From: Martyn White
Sent: 07 December 2018 14:47
To: Planning.Responses
Cc: Amber Willard
Subject: WA/98/18/HH

WA/98/18/HH

Site plan, 1:100 at A2
(All dimensions in mm unless otherwise stated)

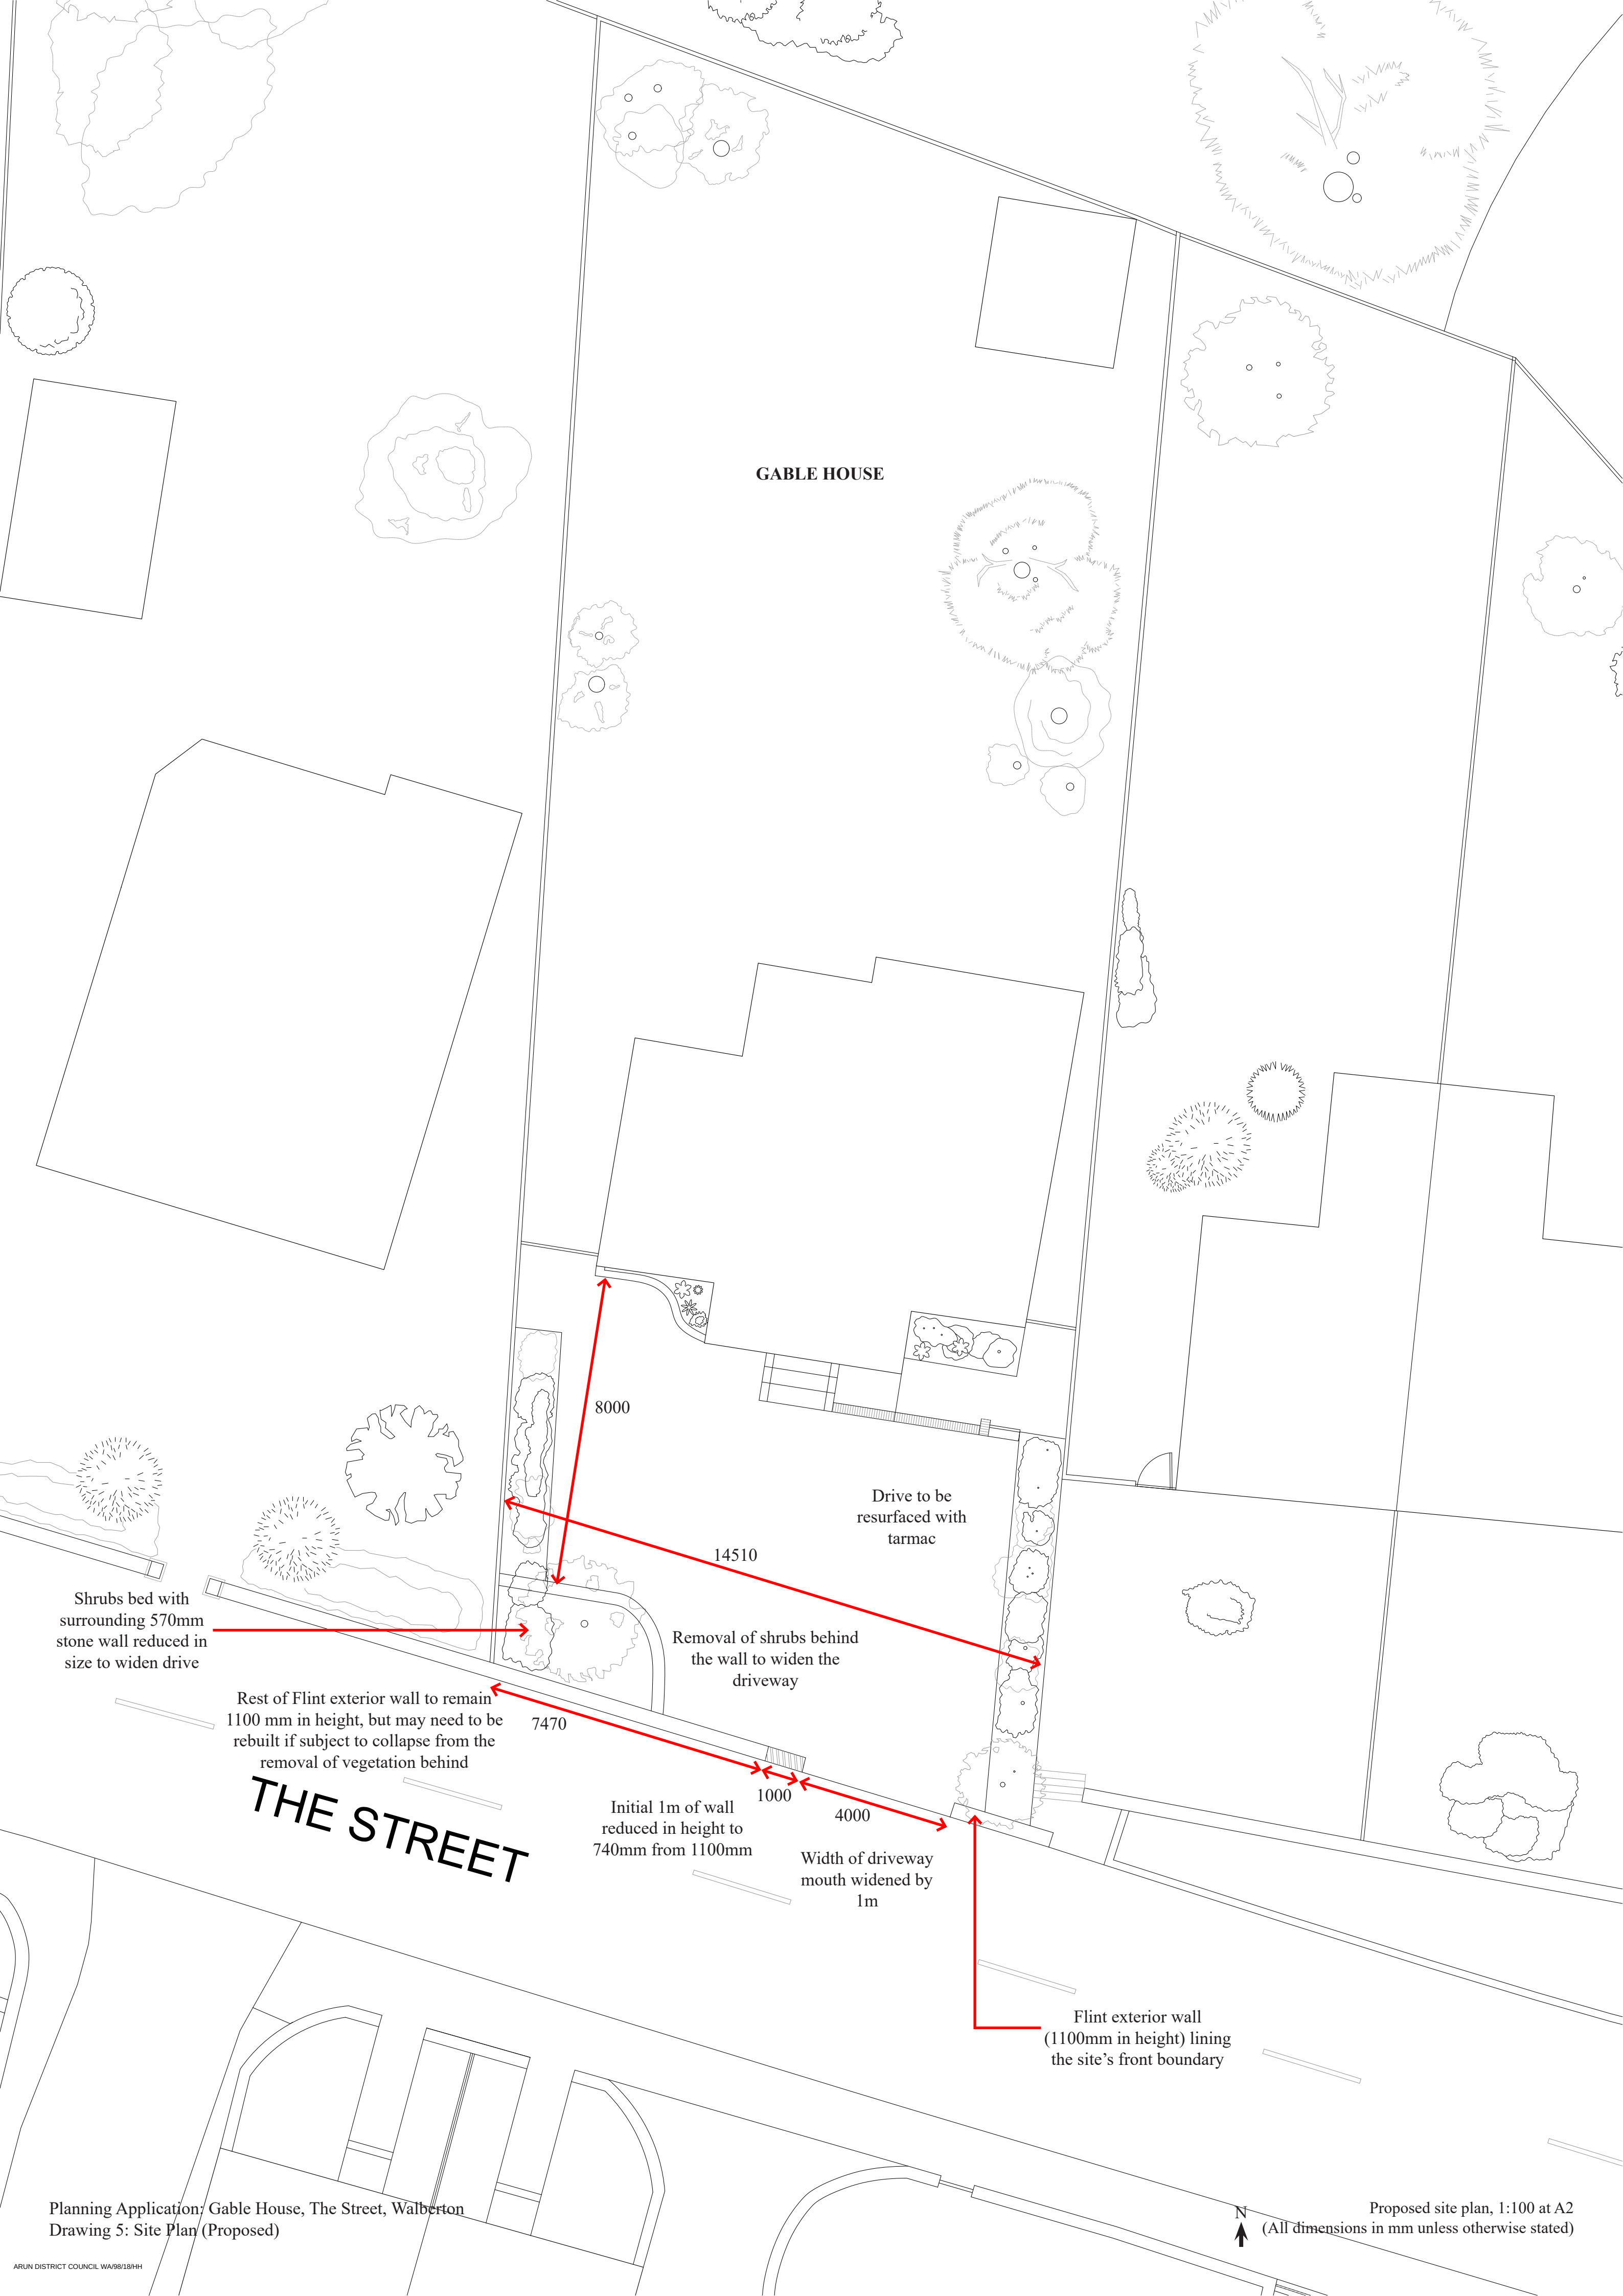
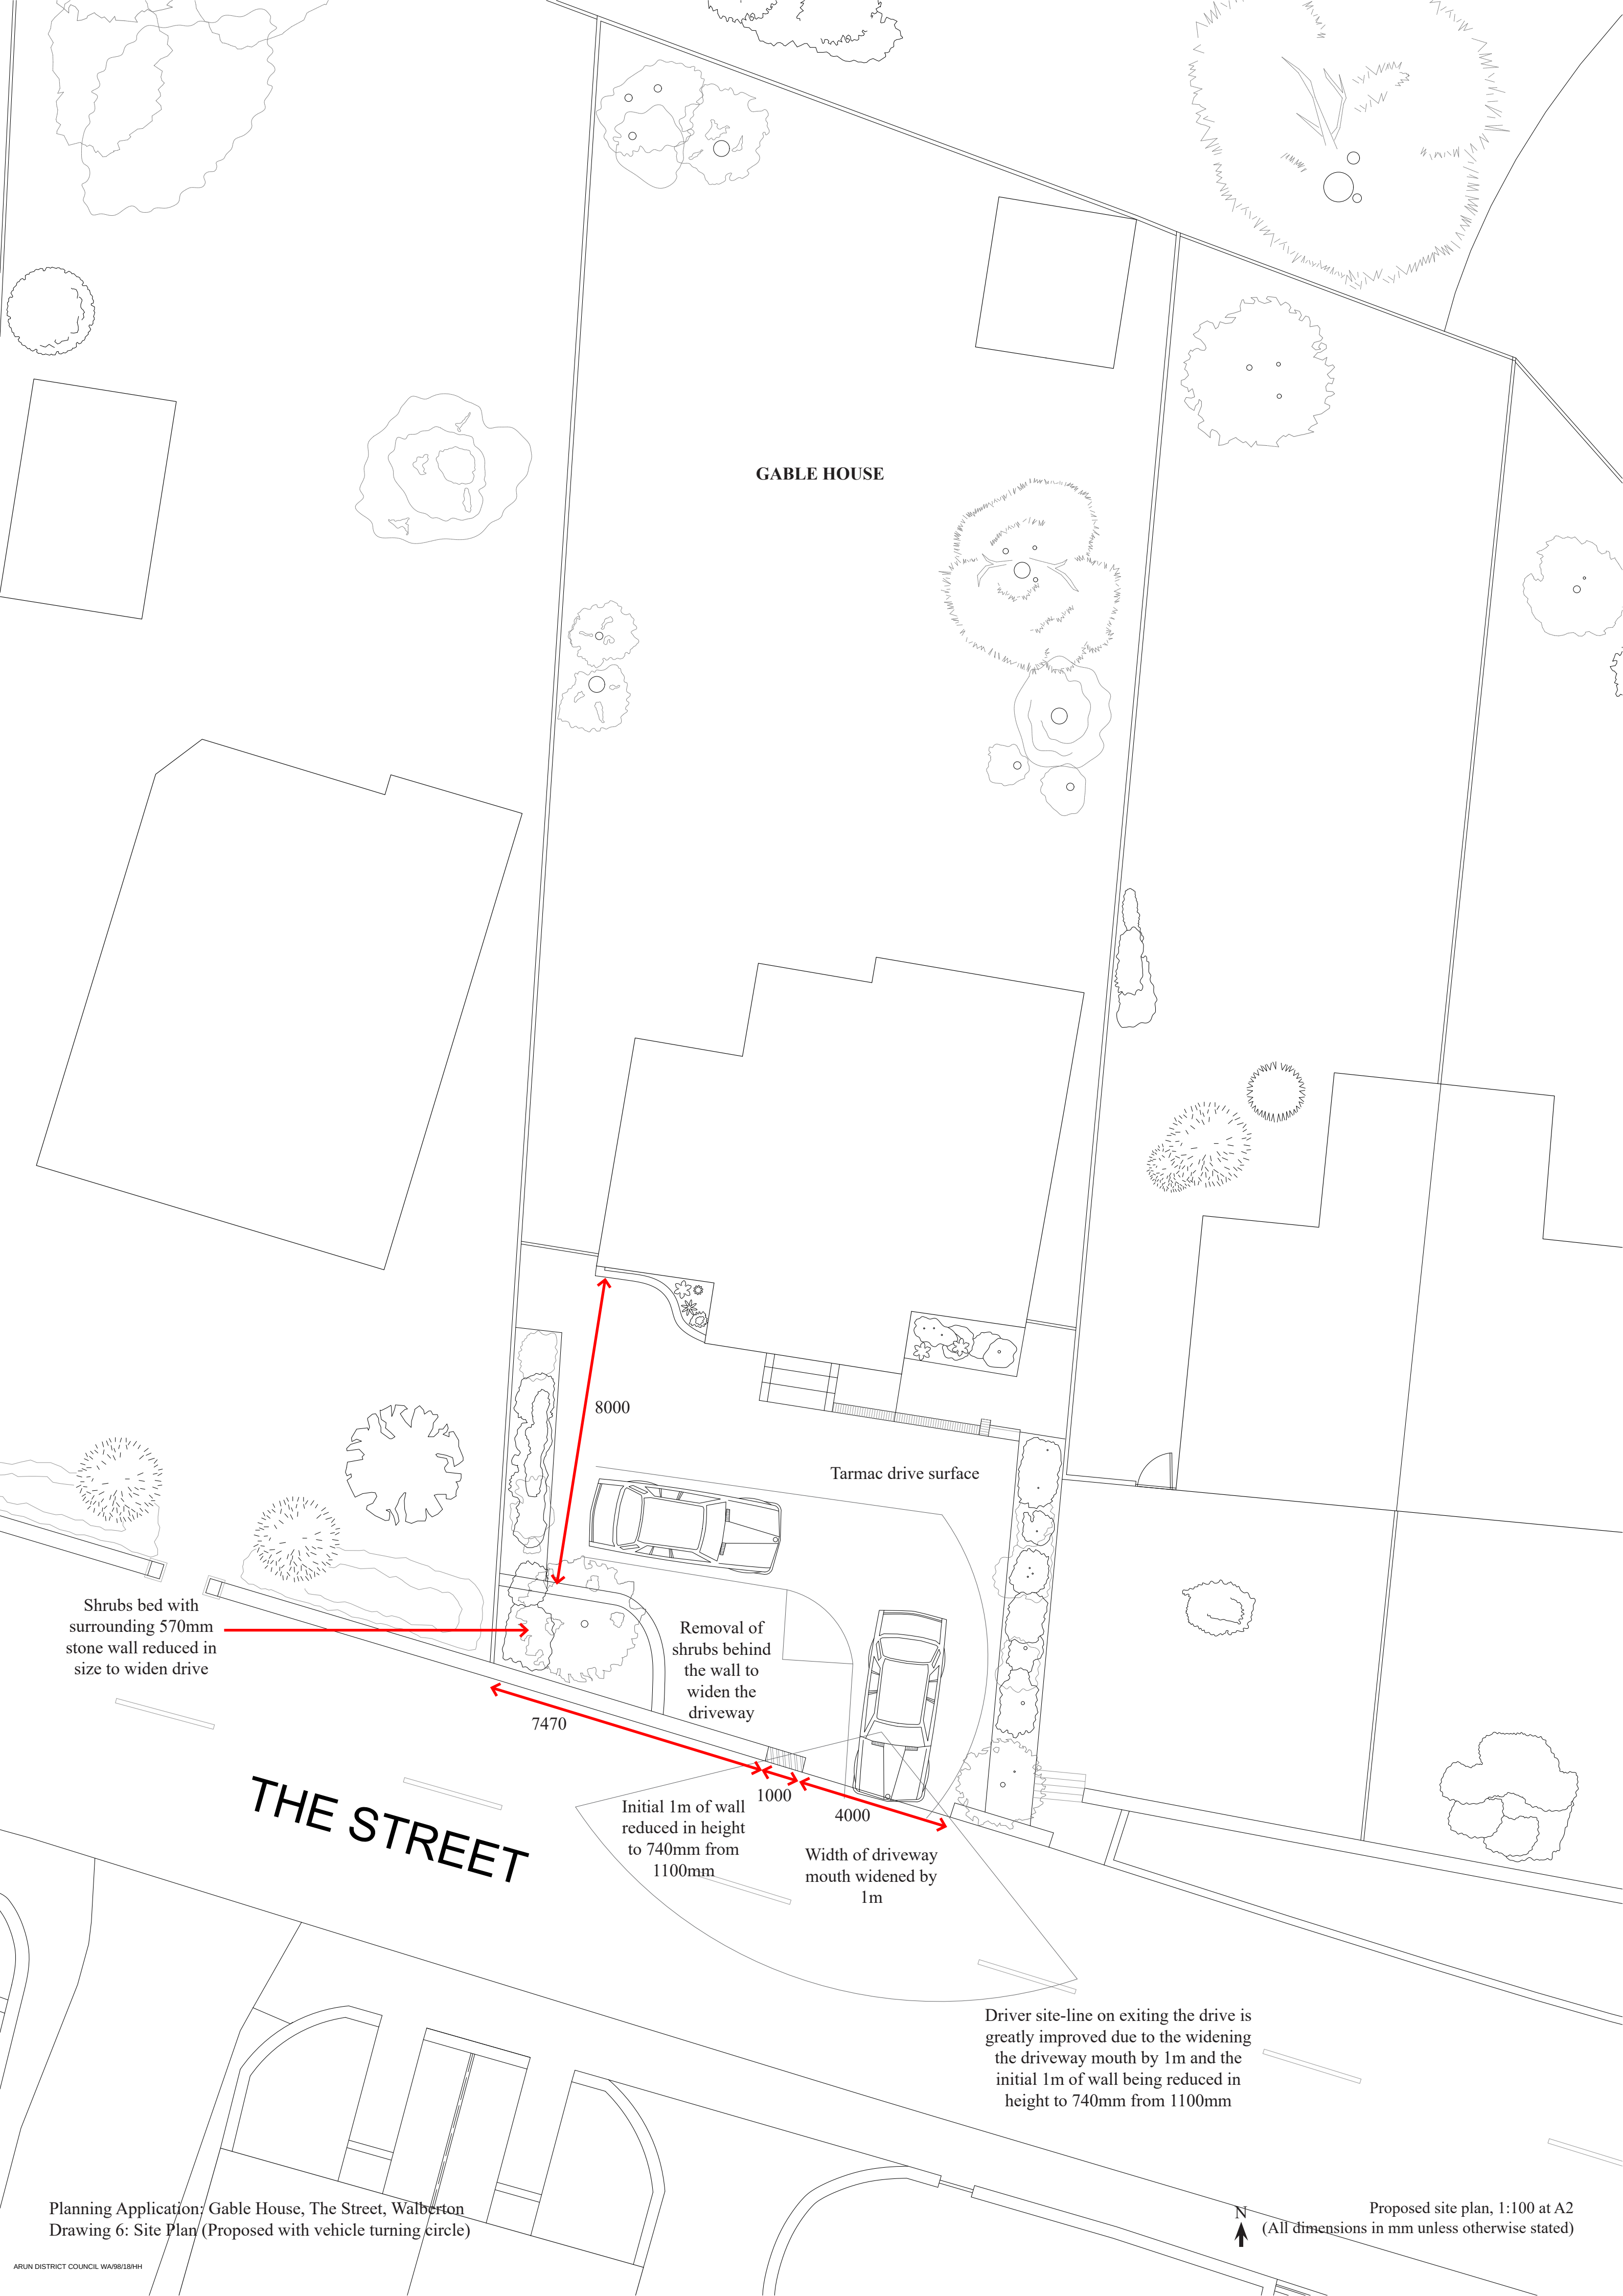
I note from the application that the proposal involves two areas of work directly to the wall. The first part involves the removal of a 1m section of the walling in its entirety, whilst the second involves reducing the height of another 1m section of the wall down to 740mm.

The loss of the vegetation is unfortunate, but it appears as if this can be undertaken with the need for consent. Likewise, the works to the wall are unfortunate as it will result in the loss of a section of attractive walling. However, it is considered that as the proposal affects the minimum amount of walling required to access the property safely, they can be considered acceptable in this instance. All of the existing flints to be removed should be retained for re-use or works of repair. The existing bricks should be re-used where possible, or replaced on a like-for-like basis.

However, of concern is the reference to the fact that the section of wall to be retained at its original height may need to be rebuilt if subject to collapse from the removal of vegetation behind. If this is proved to be the case, all of the original materials should be retained for re-use. Further, the appearance of the flint wall should be replicated exactly in terms of details such as coursing and the proportion of flint to mortar. This will require a record to be made of the existing wall in terms of its appearance (prior to works commencing), a copy of which should be passed to the Local Planning Authority.
